Application No: EP/9/22/HH
Site Address: 4 Selhurst Close East Preston BN16 2SR
Description of works: Single storey front extension and conversion of integral garage.

Thank you for your internet representation made on 10th March 2022 which has been recorded as an objection with the comments as follows:

Drawing Name
Ground Floor Plan -
Proposed

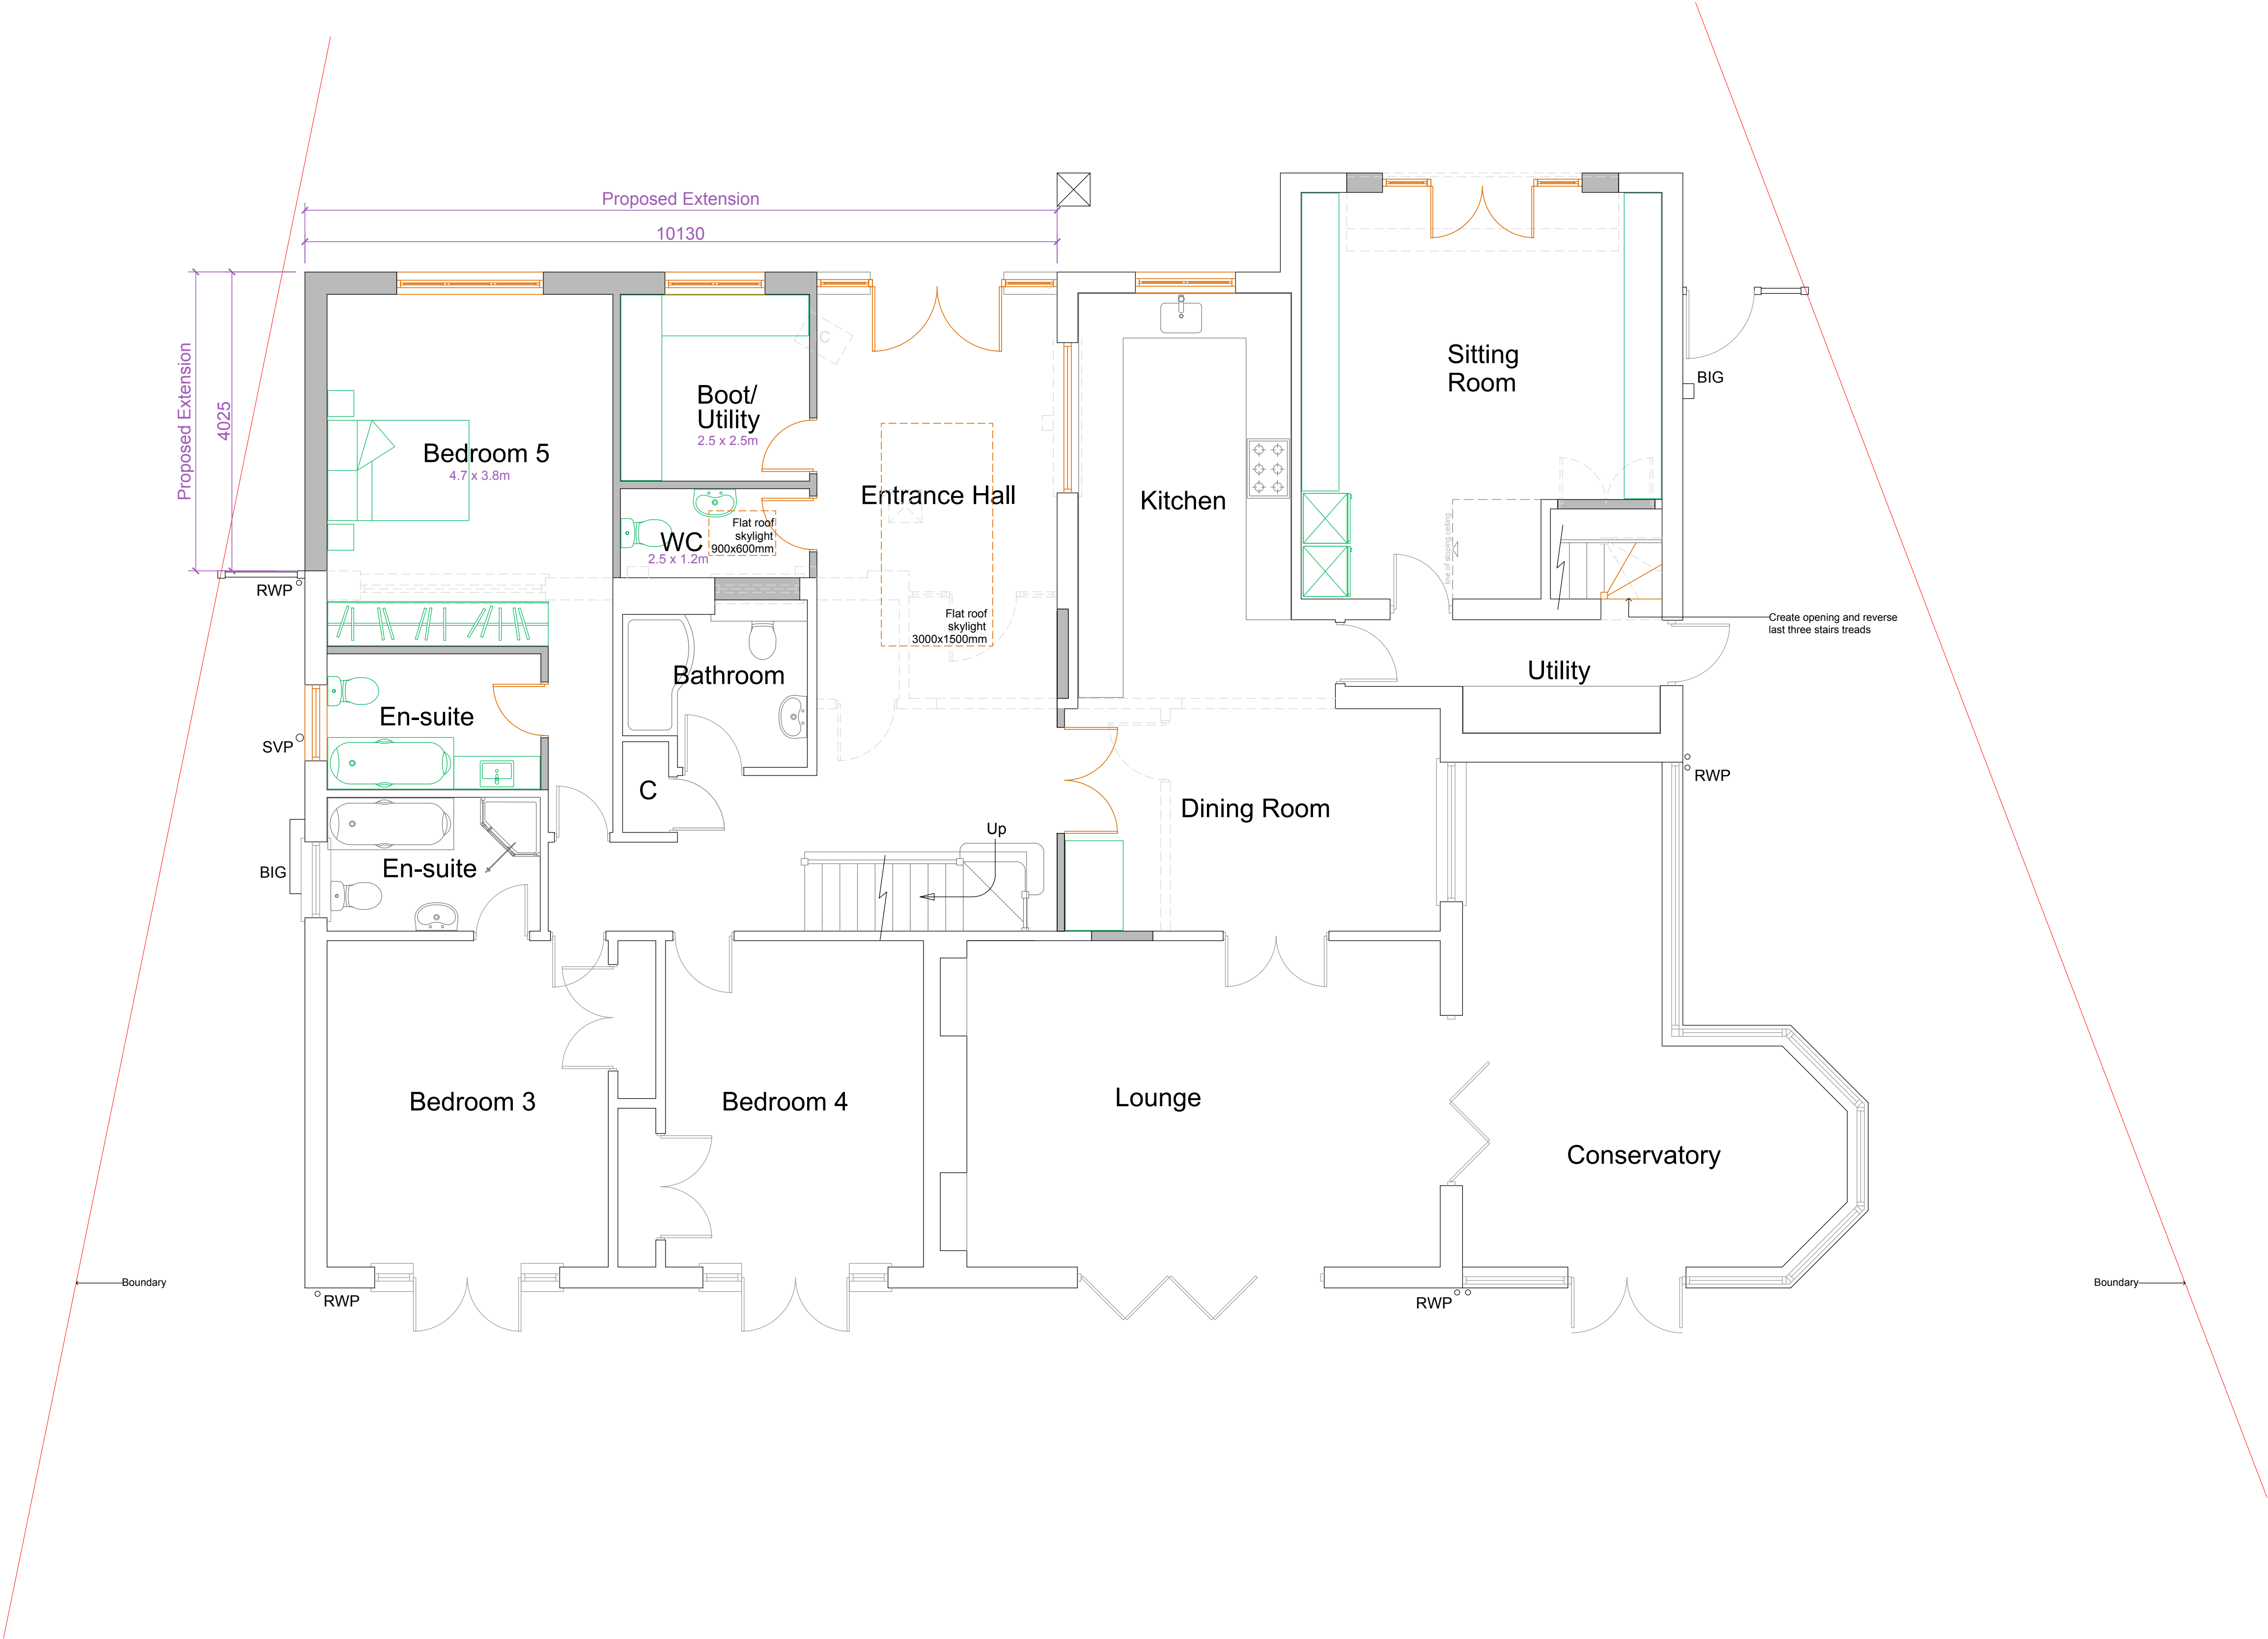
I write on behalf of the East Preston and Kingston Preservation Society to convey our concerns about these proposals. This application proposes an extension which, at its north-east corner, would be no more than 30cm from the boundary fence - possibly less at eaves level. This would present a cramped appearance in an area characterized by spacious development, contrary to Policies D DM1 and D DM4e of the Arun Local Plan and Policy M of the Arun Design Guide. It would also seem to necessitate the severe pruning or removal of at least part of the hedge on the northern boundary: the Application Form states that this would not be the case.
